From: Brian Banister
Sent: 21 July 2008 15:42
To: Planning.Responses
Subject: RE: Planning Consultation on: P/86/08/L

APPLICATION NO:	P/86/08/L
Registered Site Address:	15-JUL-08 Church Farm Holiday Park Pagham
Grid Reference:	488597 - 97491
Category:	Listed Bldg Con
Description of Works:	Application for Listed Building Consent for the repair & alteration to listed building at entrance to Church Farm Holiday Park, works required to return existing building to a condition commensurate with the listed status.

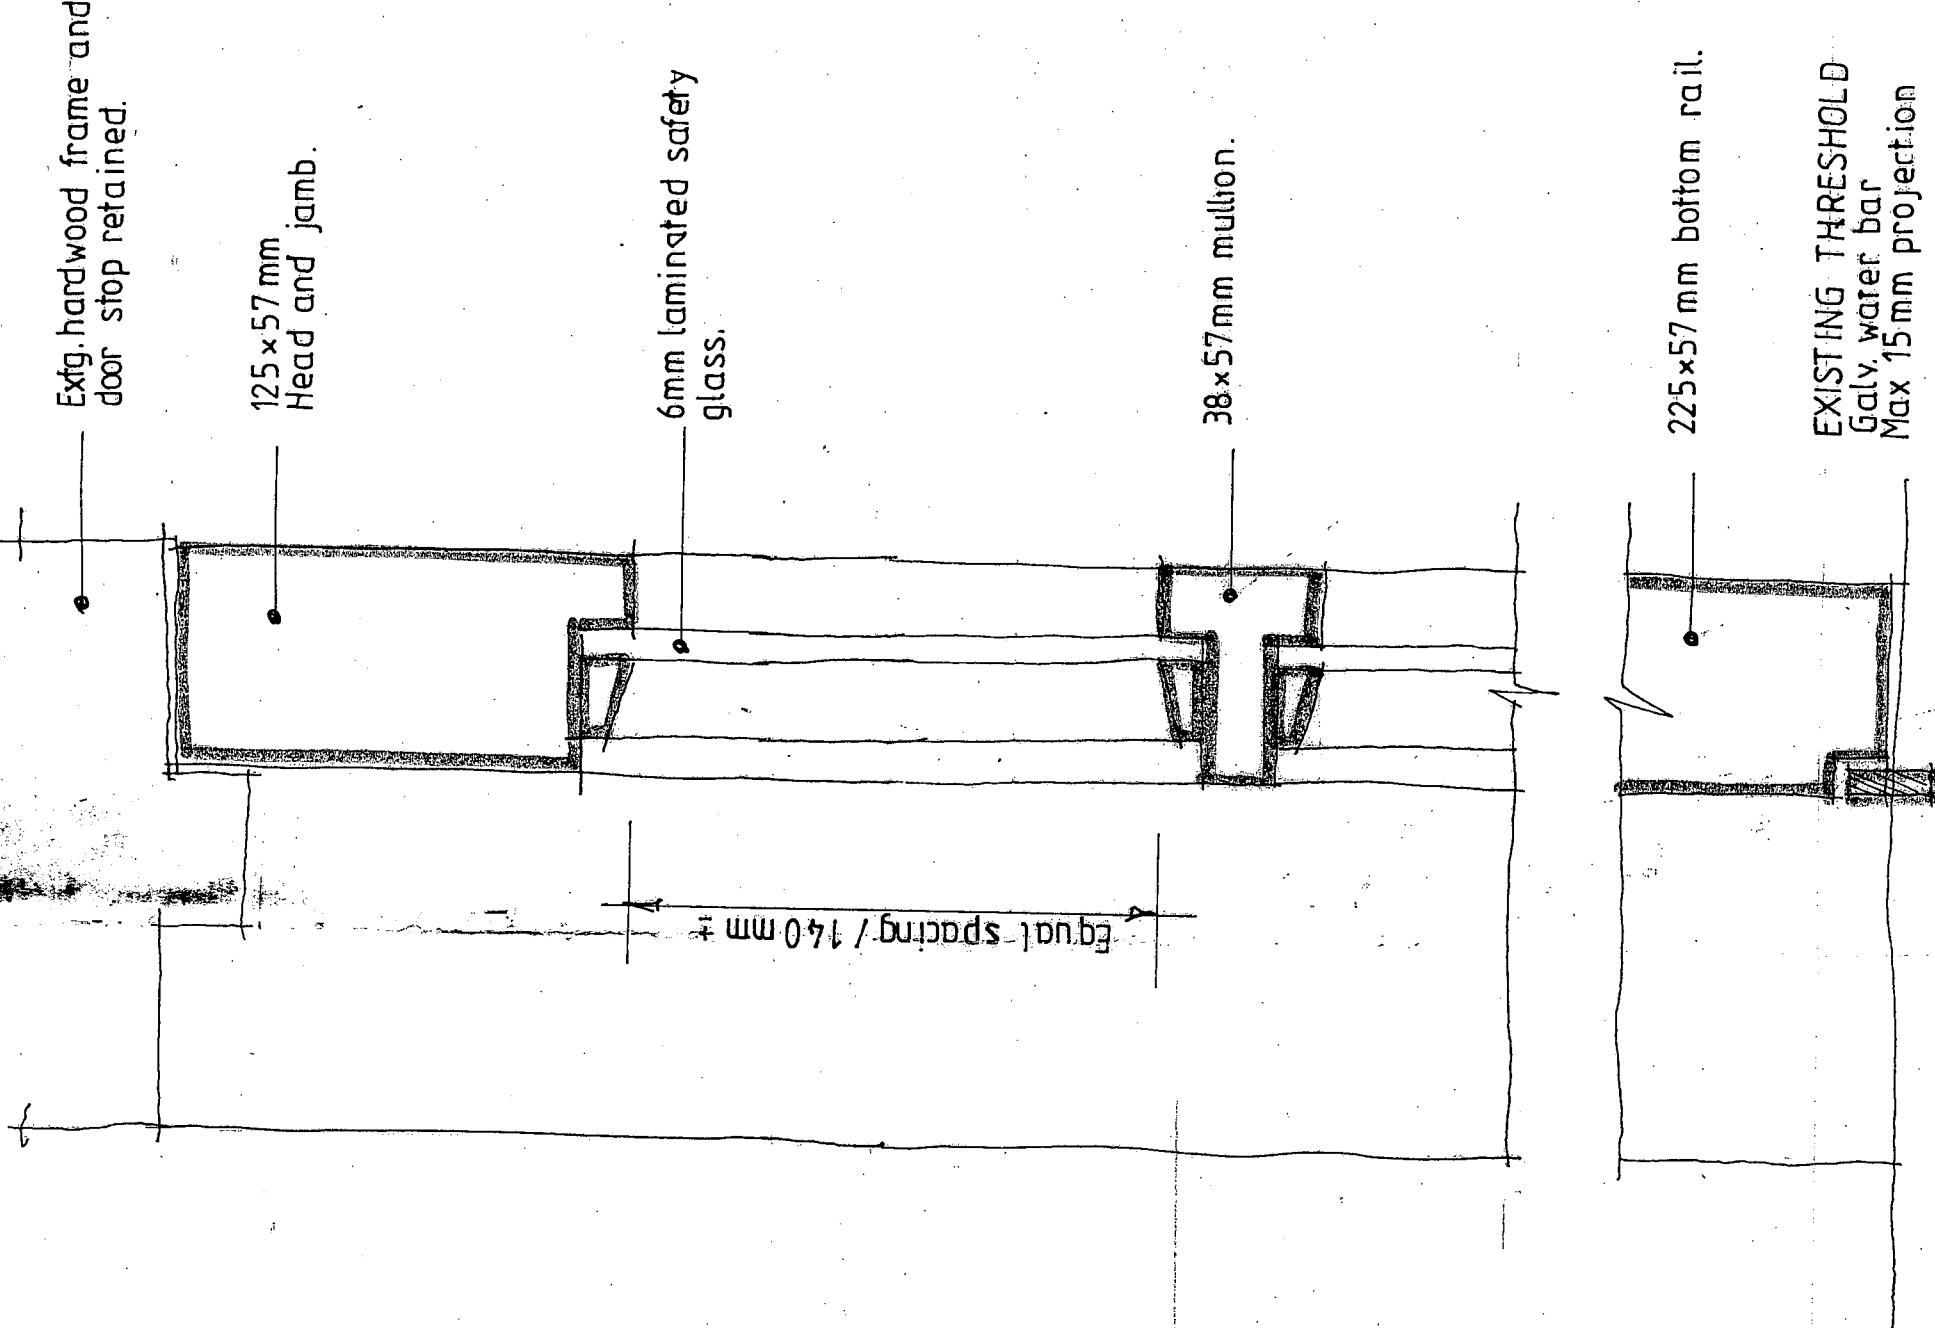
No objections. I thought they were going to change the main front door but I can't see any details.
 Brian Banister
 Conservation and Design Manager
